340-F-  
001

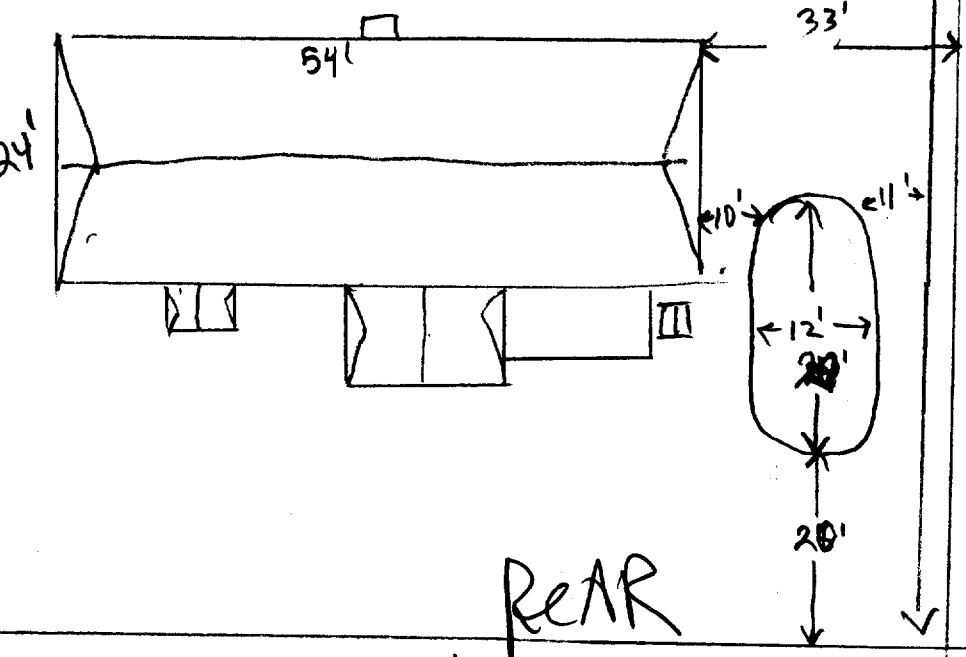
7-5-00 Pool pre con w/ Steve w/ owner checked set backs - need more information on paper street - this pin seems to line up with the curb. Called owner to ~~verify~~ verify pin placement and get a deed to verify property dimensions, he says there is another pin at the right rear corner. Reviewed code requirements for pools & barriers - also for electrical permit. JB

7-7-00 spoke w/ Robert Cohen - he says there is no other monumentation on the Broadway side of his property, therefore we cannot determine his line in relation to the paper st. He is going to get a copy from Register of deeds of his property and come in to discuss ~~his~~ his options. JB

7-10-00 Owner will Amend Permit to Relocate JB
